City of Portland, Maine - Building or Use Permit Application
 389 Congress Street, 04101 Tel: (207) 874-8703, Fax: (207) 874-8716

Permit No: 04-1728	Issue Date:	CBL: 425 I004001
------------------------------	--------------------	----------------------------

Past Use: Commercial; Office/ Storage	Proposed Use: Amendment to permit # 040866 / Install metal joist to mezzanine for storage.	Permit Fee: \$192.00	Cost of Work: \$19,000.00	CEO District: 4
Proposed Project Description: Amendment to permit # 040866 / Install metal joist to mezzanine for storage.		FIRE DEPT: <input type="checkbox"/> Approved <input type="checkbox"/> Denied	INSPECTION: Use Group: Type	
		Signature:	Signature:	
PEDESTRIAN ACTIVITIES DISTRICT (P.A.D.)				
Action: <input type="checkbox"/> Approved <input type="checkbox"/> Approved w/Condition <input type="checkbox"/> Denied				
Signature:		Date:

142 Pennington St
 RAILINGS
 YGSI Y

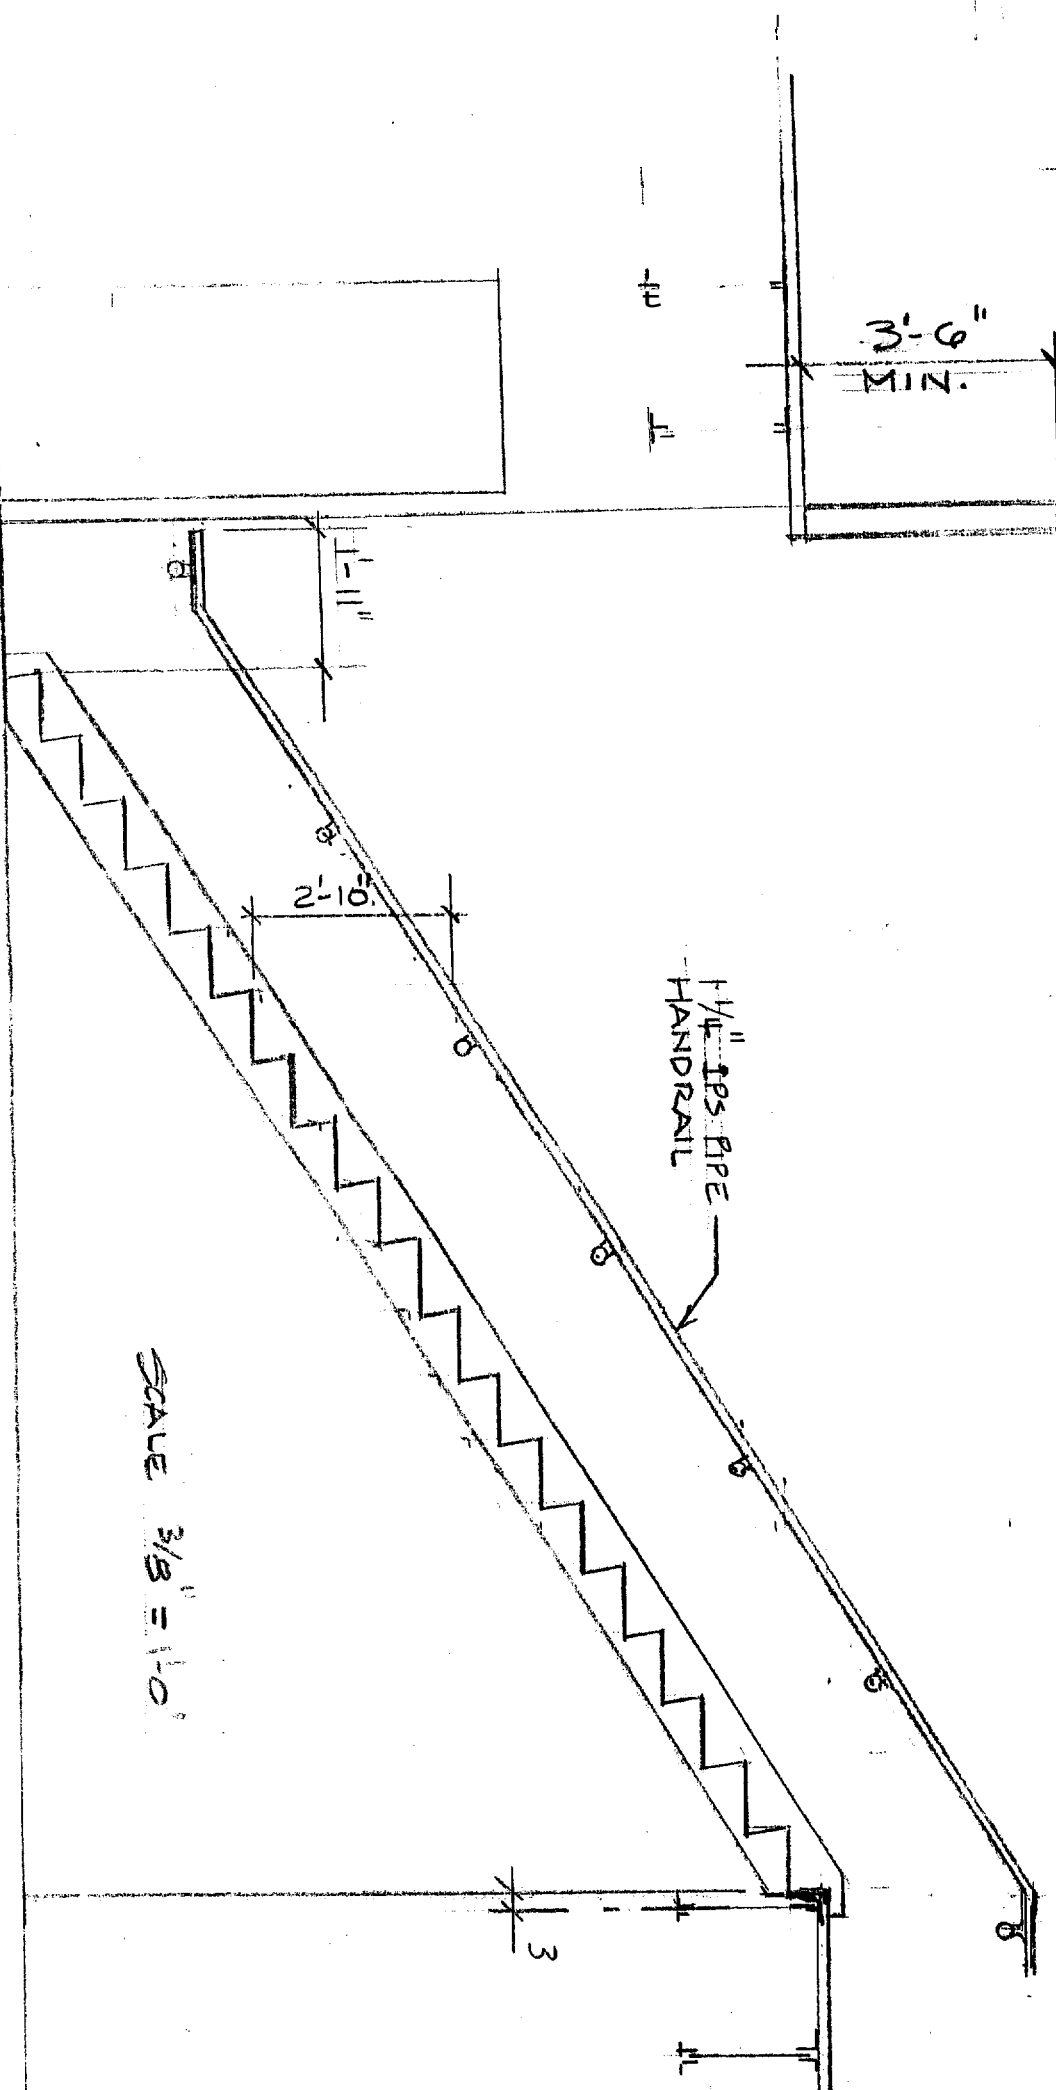
Comments:
12/29/2004-ldobson: dropped by additional info 12/23/2004
12/14/2004-mjn: Plans insufficient, owner and engineer notified.....
Need: laoding/use/complete stair detail/Guards/Openness/The framing details appear to be incomplete
